# Whalley Parish Council

## **PLANNING APPLICATIONS 3/2016/0387**

Proposal: Demolition of stone boundary, creation of two storey extension for ground floor retail and first floor on bedroom flat  
Location: 3 Accrington Road, Whalley BB7 9TD

PROPOSED FRONT ELEVATION

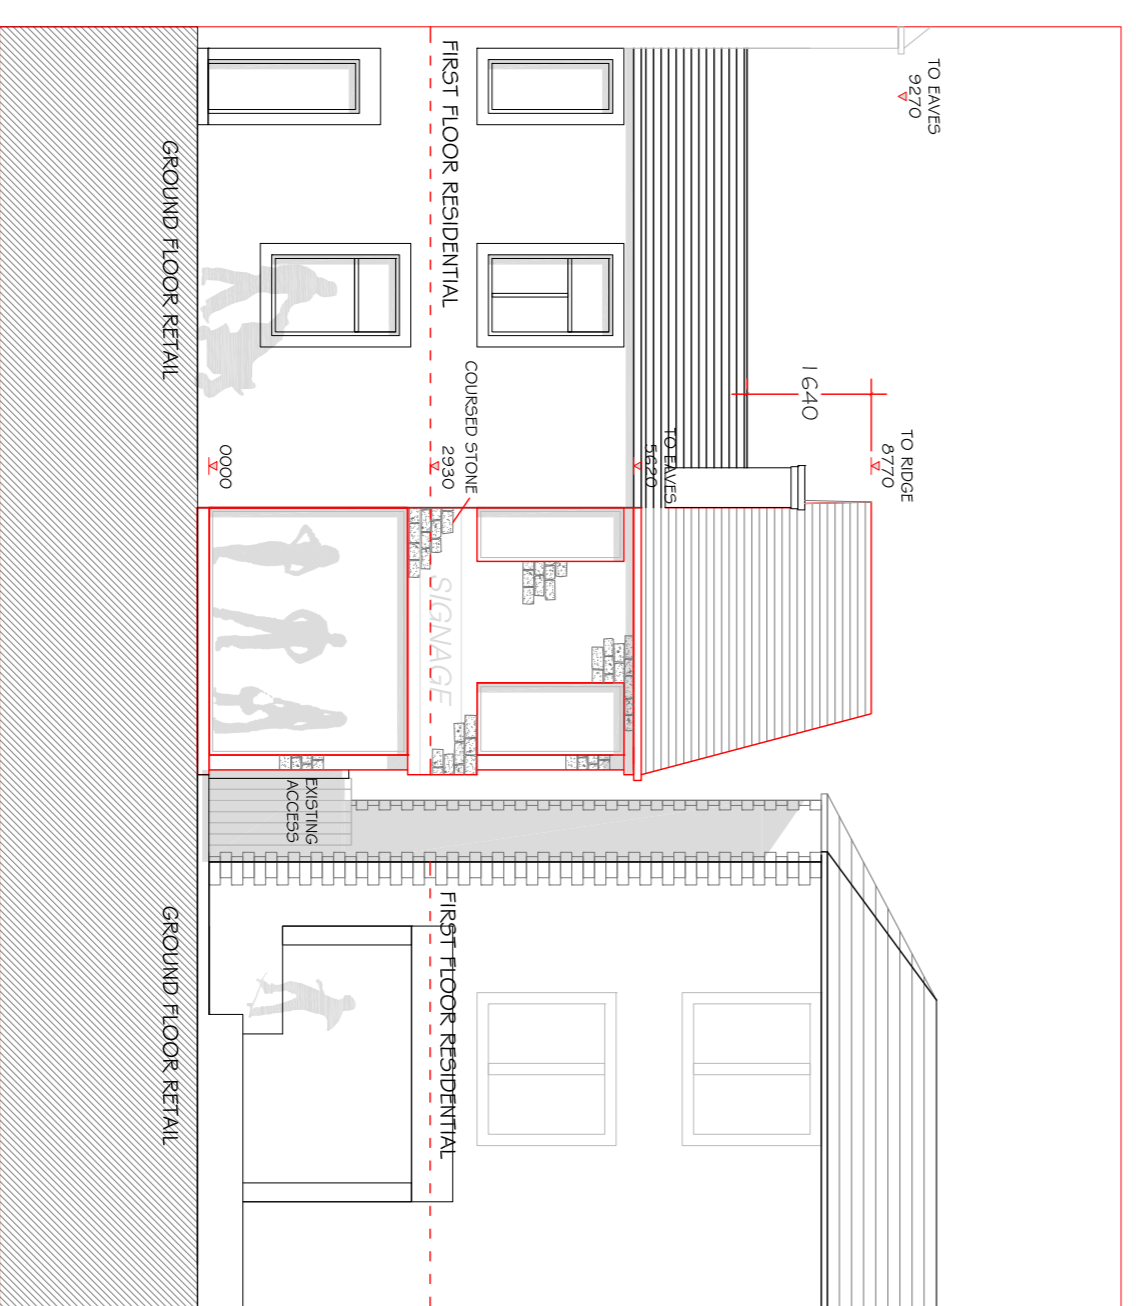
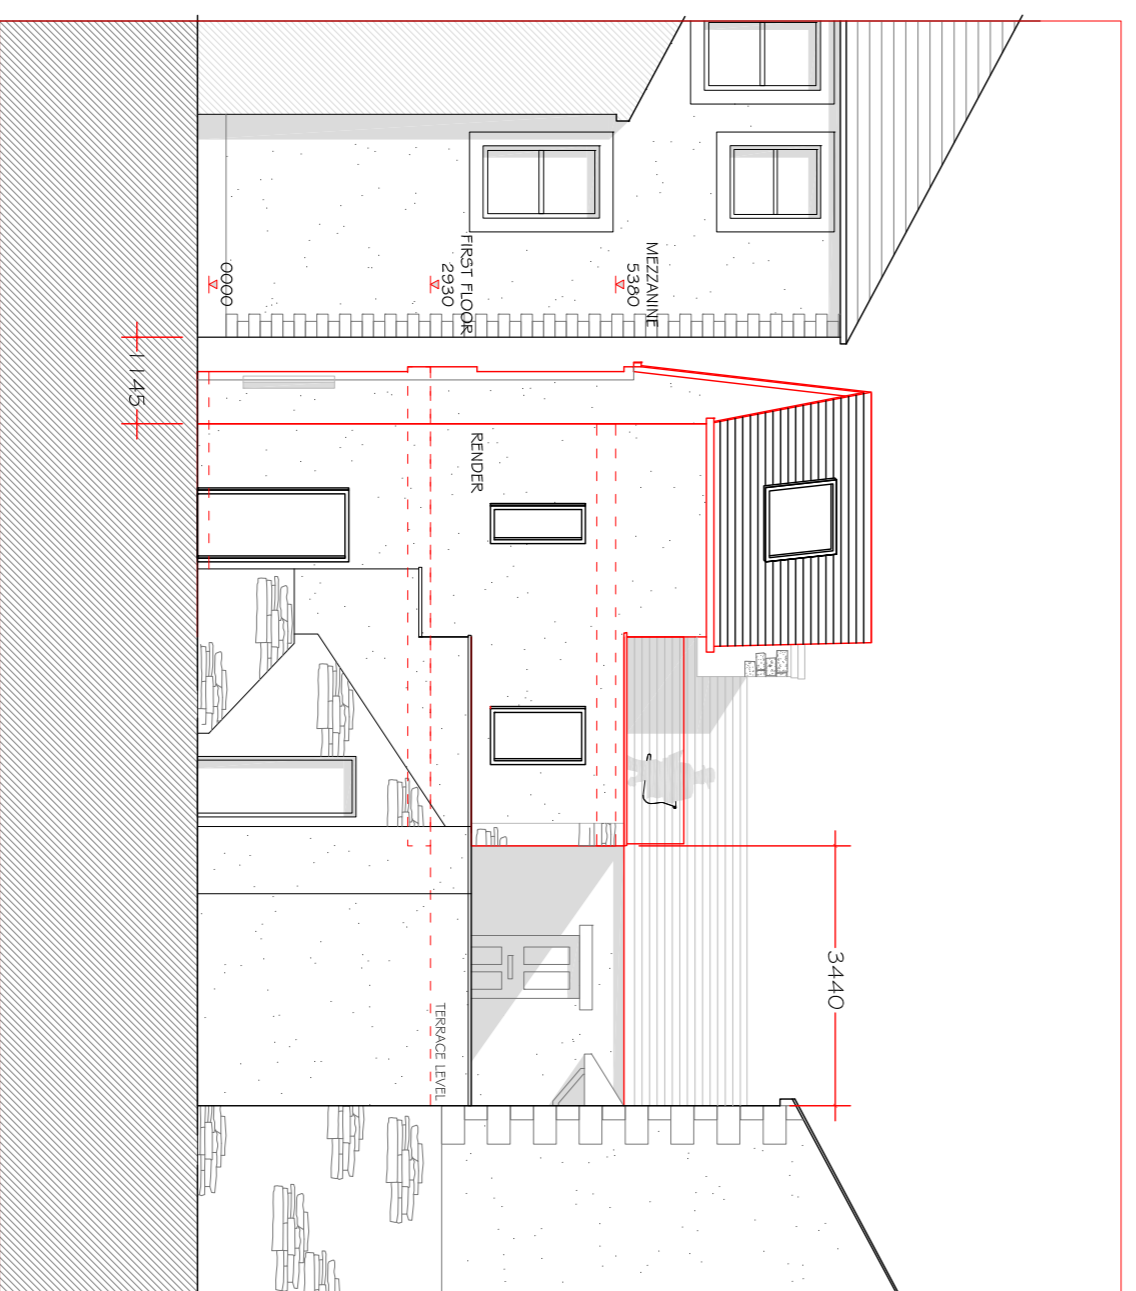
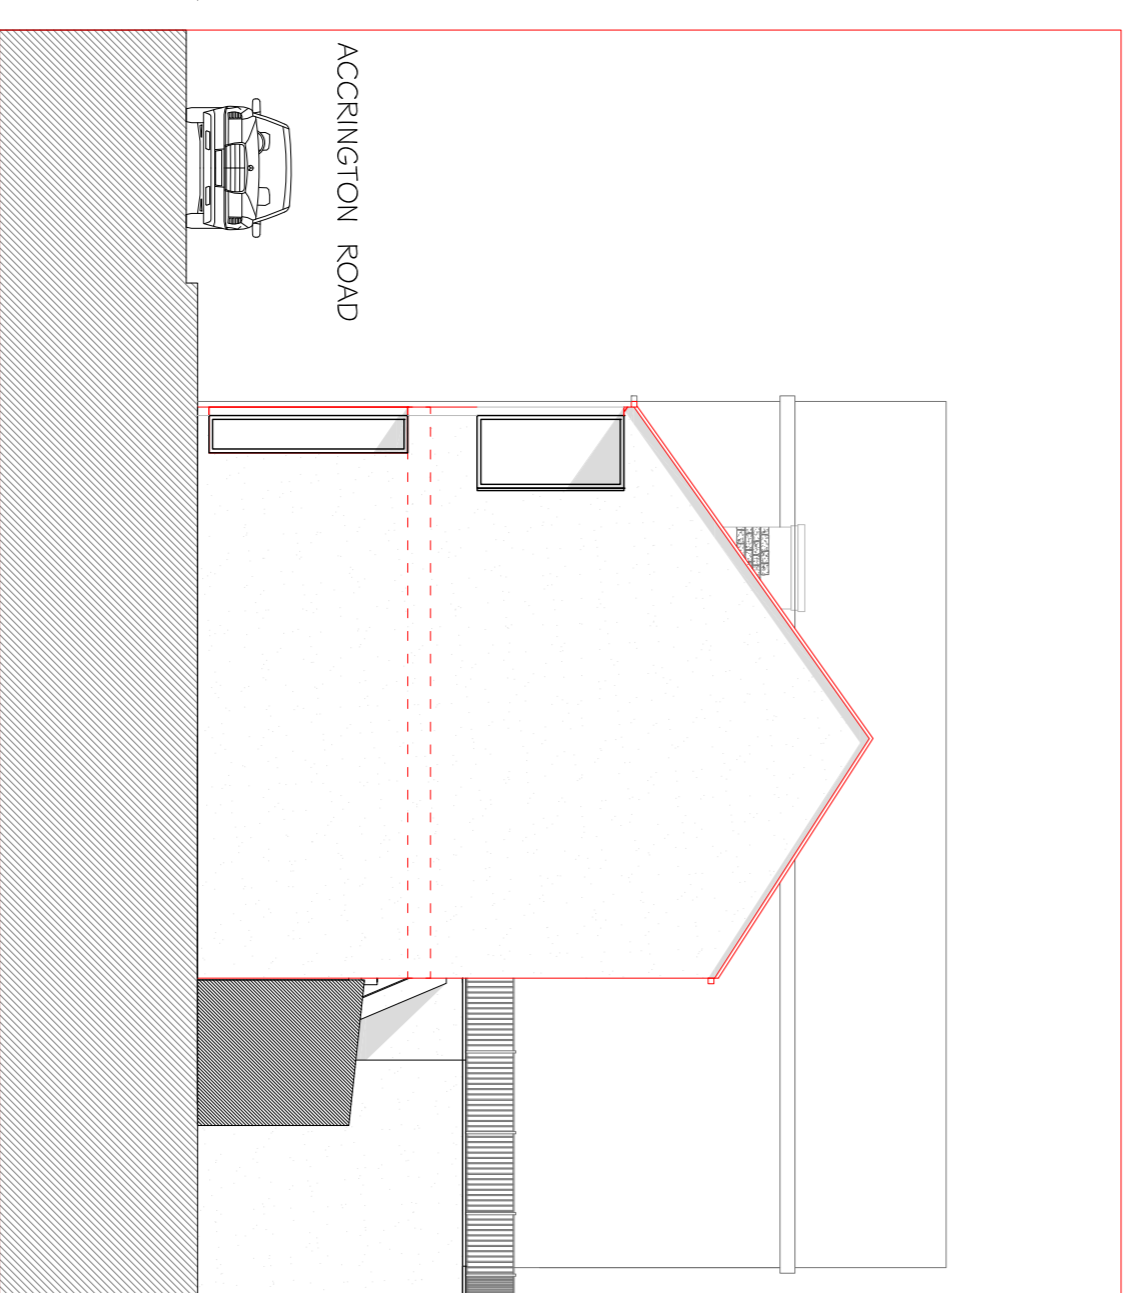
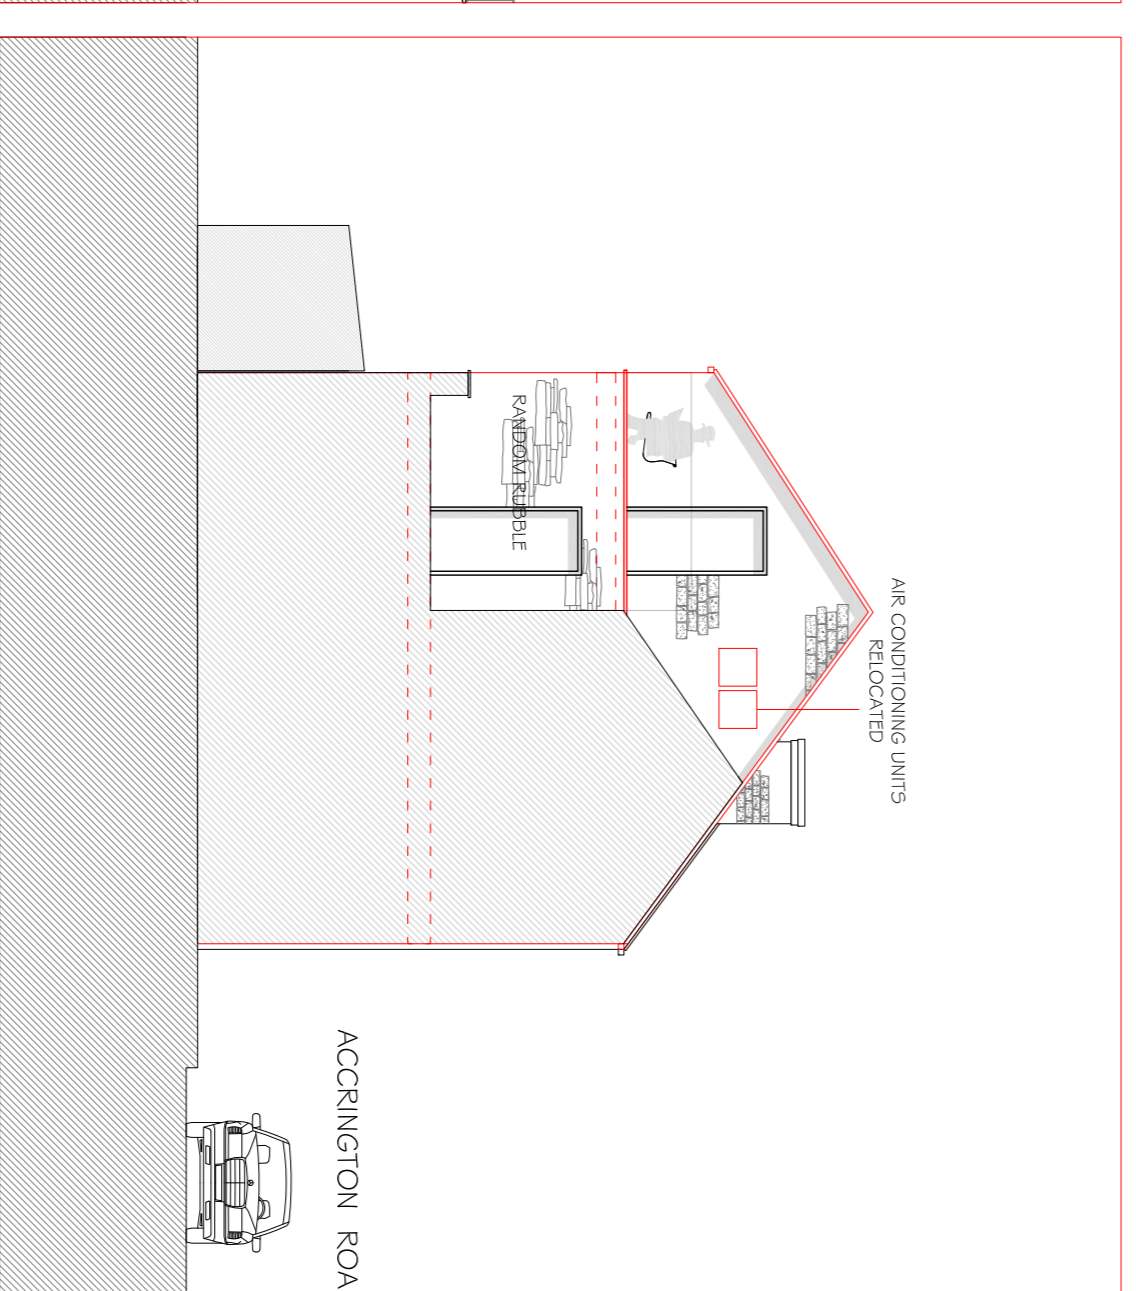
The roof of the extension will follow the same line as the existing roof at number 3, Accrington Road, but will project beyond that of number 3 and so have a higher roof line of 1.6m. The Parish Council believes this will give the build an incongruous look in the setting of the existing buildings, particularly for the side and rear views. Considering that this is in the Conservation area of Whalley, this extension is unsuitable.

If the brick work of the extension does not match exactly that of number 3, then this would radically alter the overall appearance of that group of buildings.
